## About the application

Application number: 2024/91260	
What is the application for?:	Variation of condition 2 (plans and specifications) and 35 (removal of permitted
Address of the site or building:	Land at, Merchant Fields Farm, off Hunsworth Lane, Cleckheaton
Postcode:

status: PLANNING
 project: MERCHANTS FIELD CLECKHEATON
 site: SITE LAYOUT
 drawn: QYRB. date: MAY 2019
 checked: RB. scale: @ A0:1:500
 job no: 122. dsg no: 122-PL-01-V

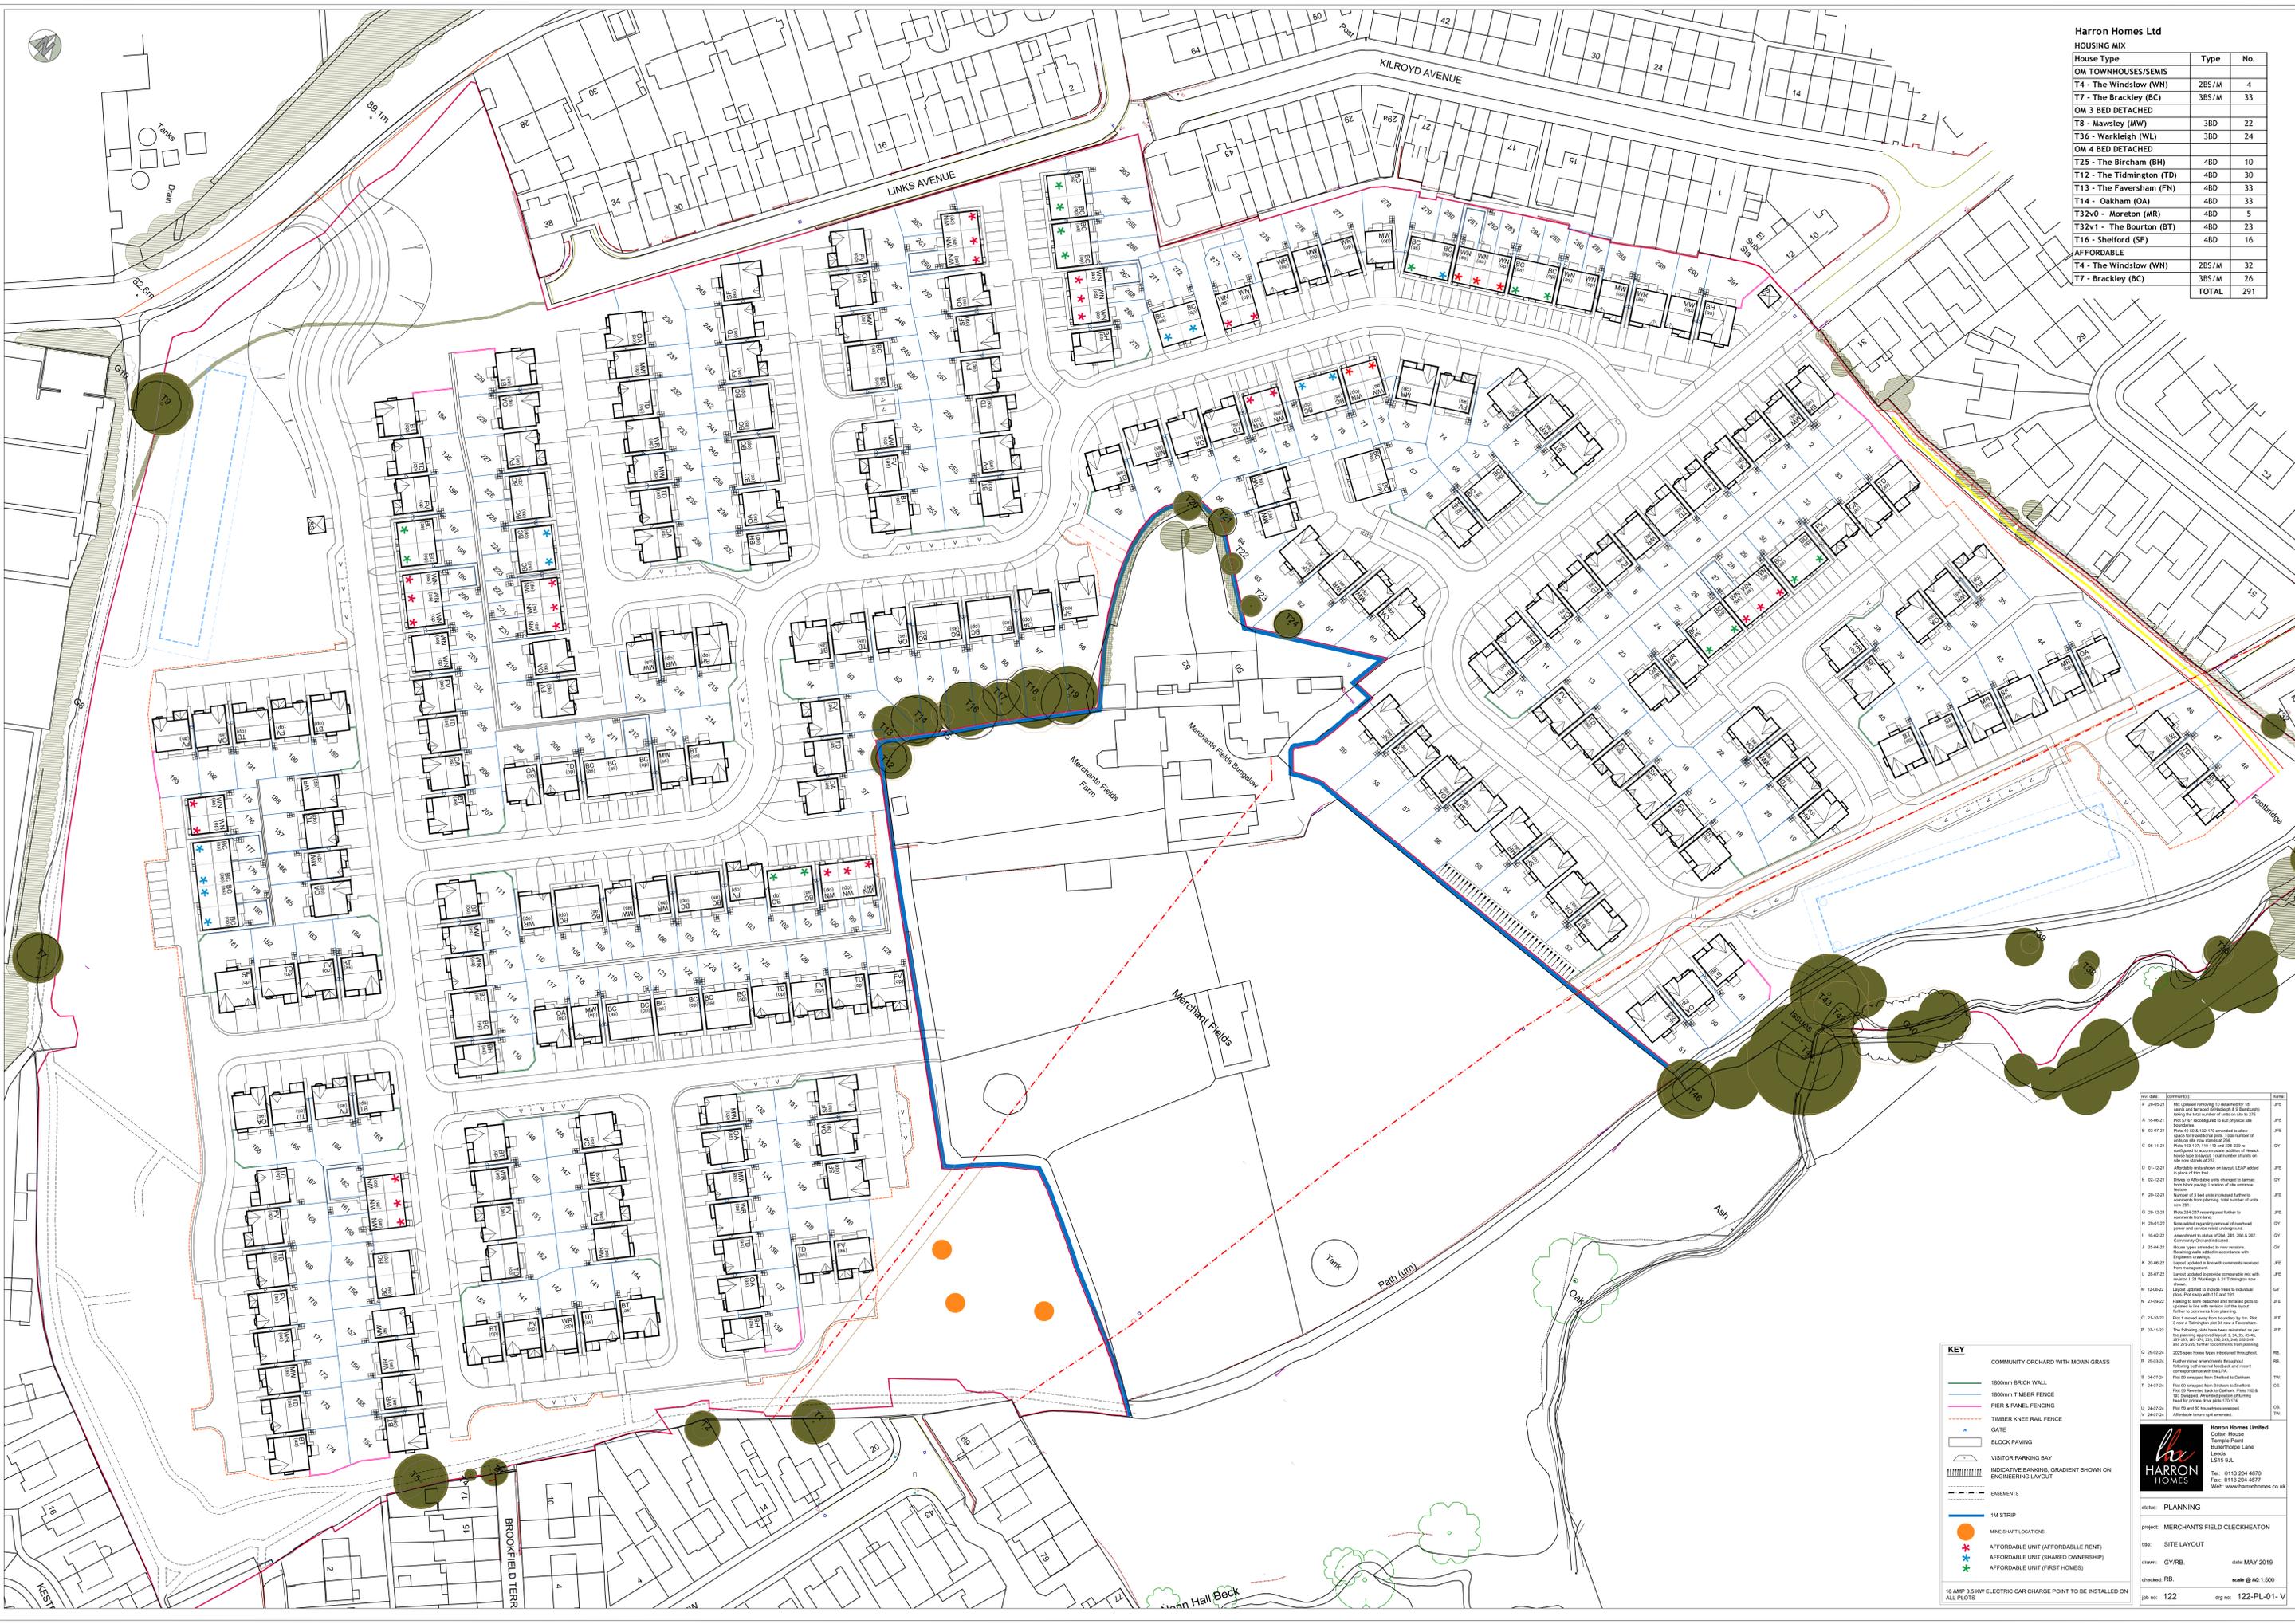
Type of comment: An objection	
Do you wish your comments to be published on the website anonymously?	Yes
<p>Comments on planned amendments</p> <p>1: At plot No 1 their now appears to be a road joining Kilroyd Drive and the proposed new development which is, as you are aware against the original planned access for 7 days only. As agreed at the Planning meeting, video archive available if this facts needs clarification in court.</p> <p>2: Destruction of valuable greenfield site, destruction of fauna &amp; flora as a consequence</p> <p>3: Pollution to Mazie Brook from building works.</p> <p>4: Increased flood risk as per Yorkshire Water Report., especially downstream of the development.</p> <p>5: Air pollution due to massive increase in slow moving traffic in and around the area.</p> <p>6: Light pollution due to excess size of development</p> <p>7: Noise pollution due to increased human habitation rather than green field.</p> <p>8: Reduced sunlight on in our case south facing aspect to rear of our property</p> <p>9: We will be overlooked from several sides at the rear of our property with reduced Privacy</p> <p>10: Local traffic will be heavily affected in and around the development.</p> <p>11: Local Infrastructure barely copes with current resident levels, the increase is not sustainable within the area for schools, doctors, dentists, emergency services, pharmacies and hospitals.</p>
